# Rezoning Transportation Analysis

Petition Number: 2022-156

**From:** Jake Carpenter, PE

Date	Description
02-23-23	First Review (JLP)
03-23-23	Second Review (JLP)
04-19-23	Third Review (JLP)
06-28-23	Fourth Review (DR)
07-26-2023	Fifth Review (PDM)

RZ1.00

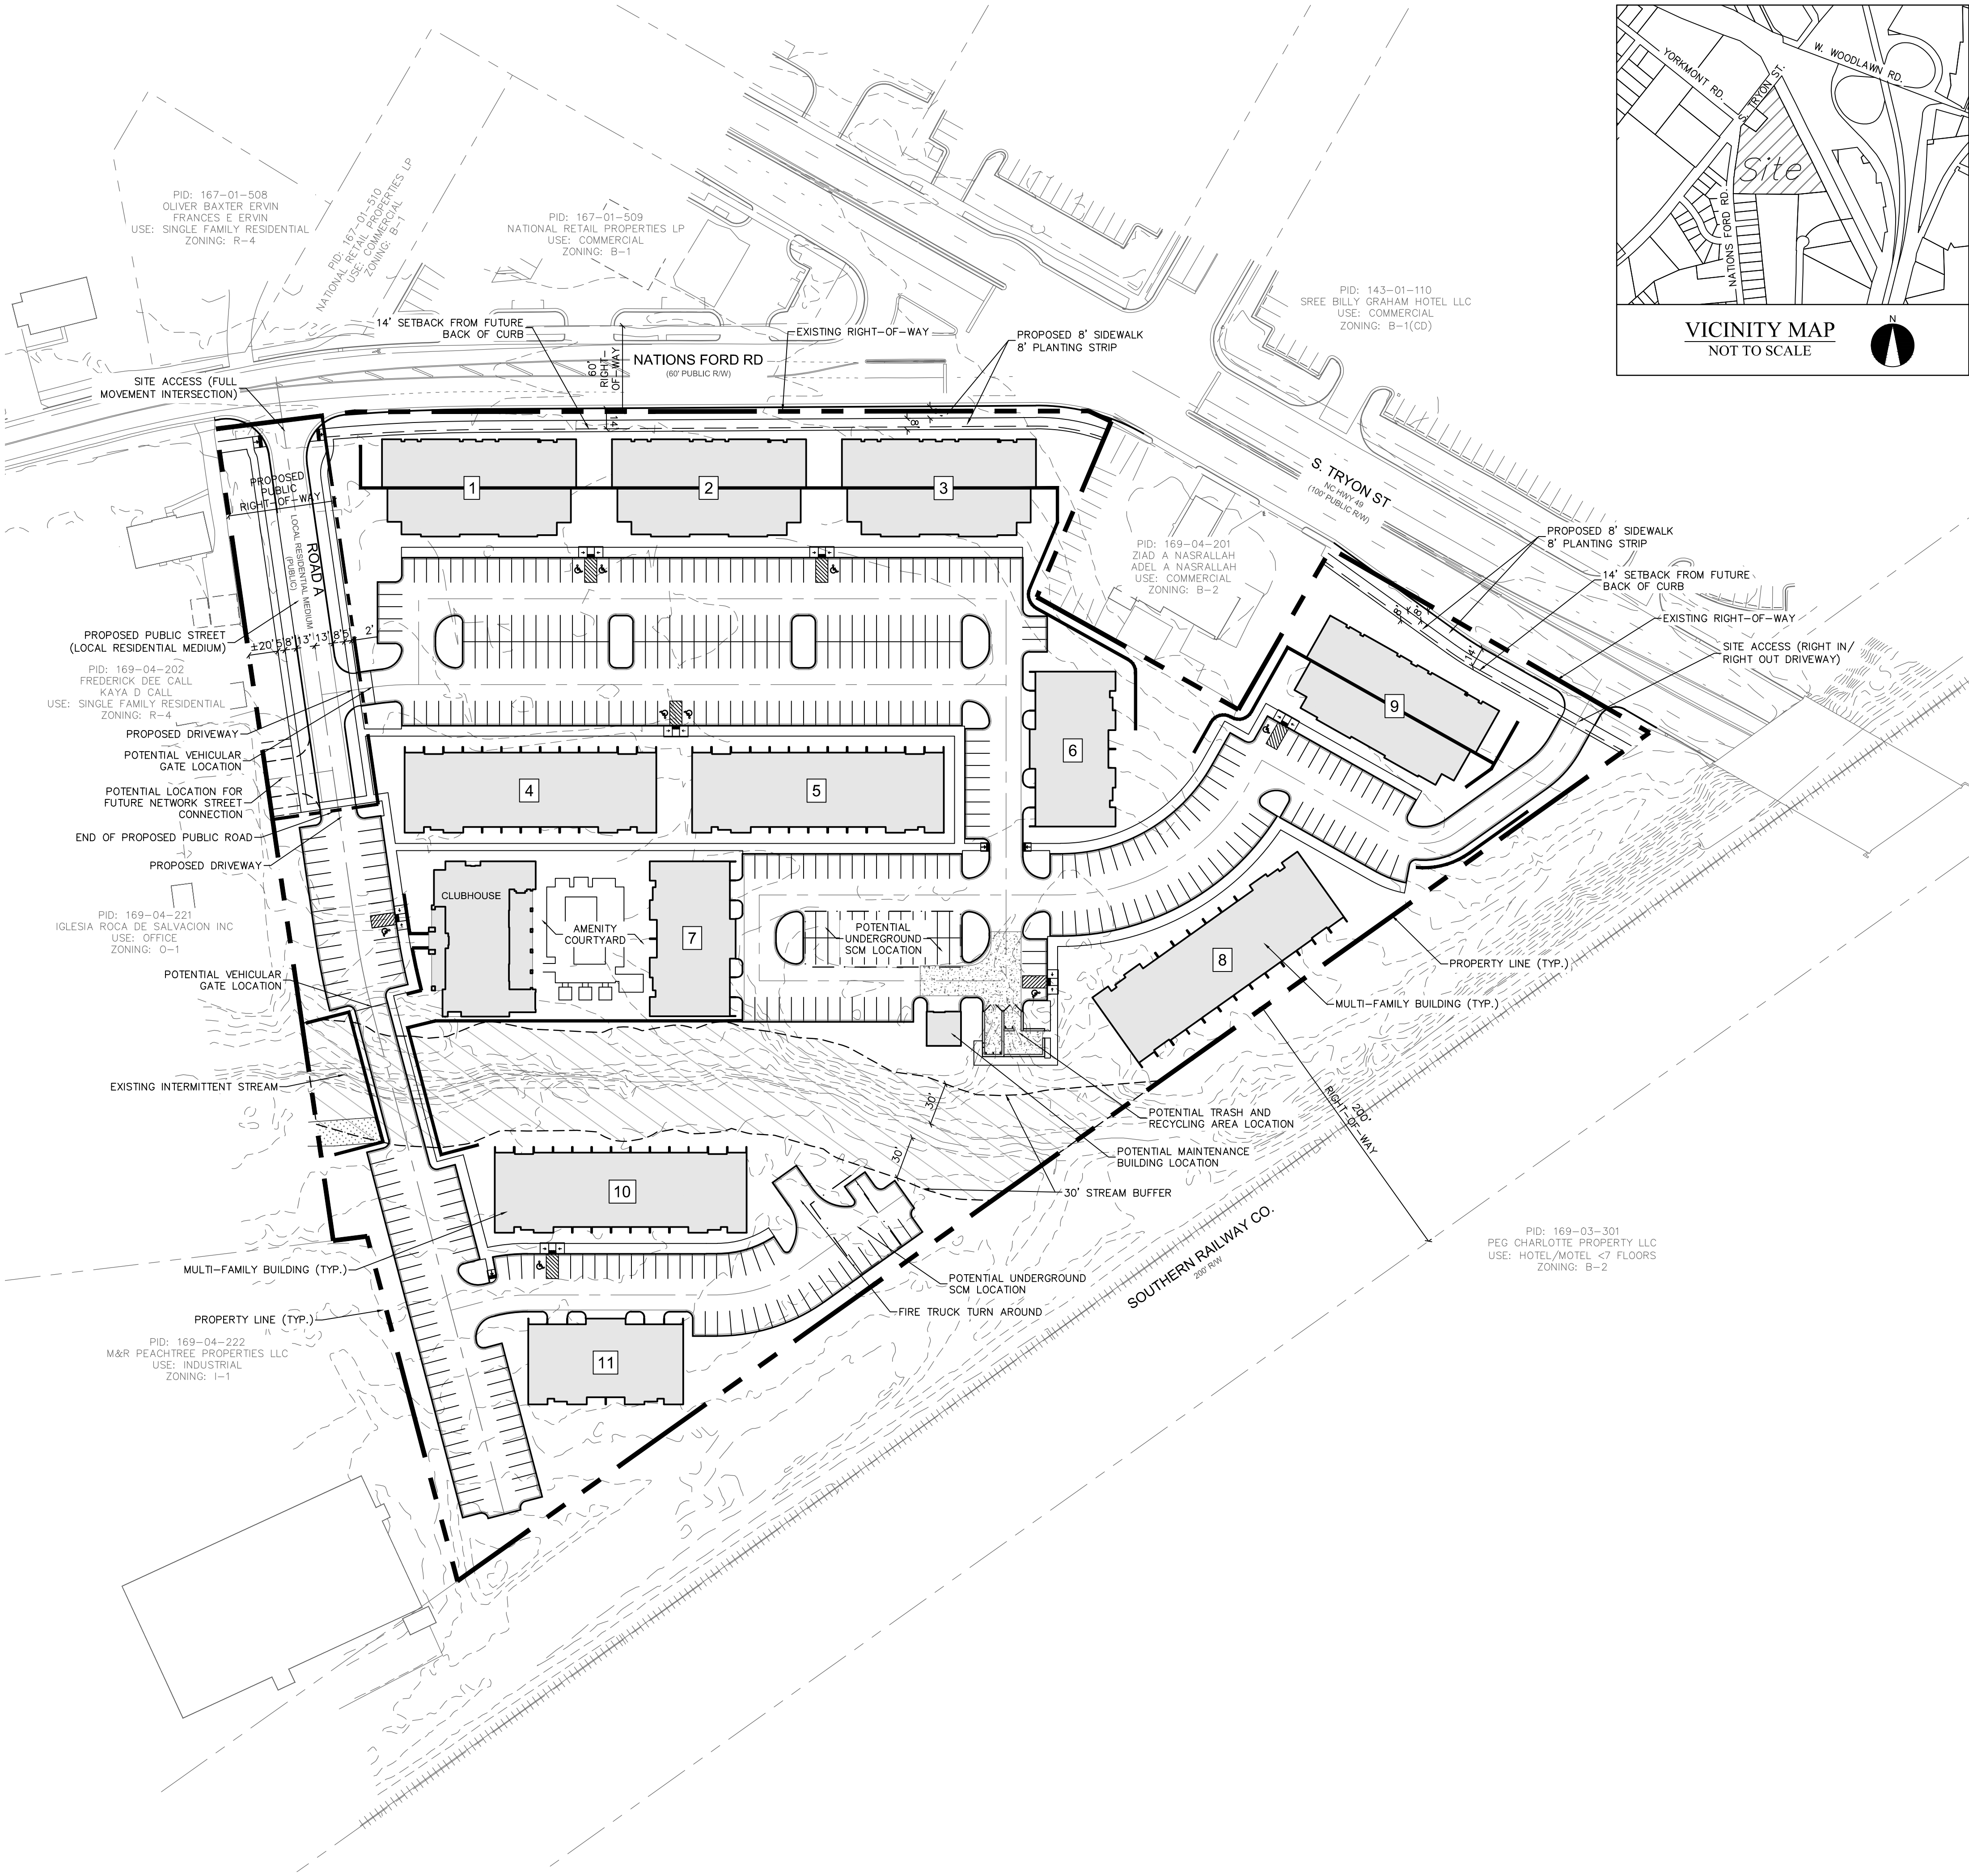
**Clarifying Comment 4/19/23:** Road A still needs the ROW and back of curb to be dimensioned

**Clarifying Comment 3/22/23:** Shift bike ramp to precede the pedestrian crossing, extend MUP to new ramp location.

Revise potential gate located to be a minimum of 40ft from the proposed right of way

~~Clarifying Comment 6/28/23: Remove the pedestrian crossing and associated callout below from site plan.~~
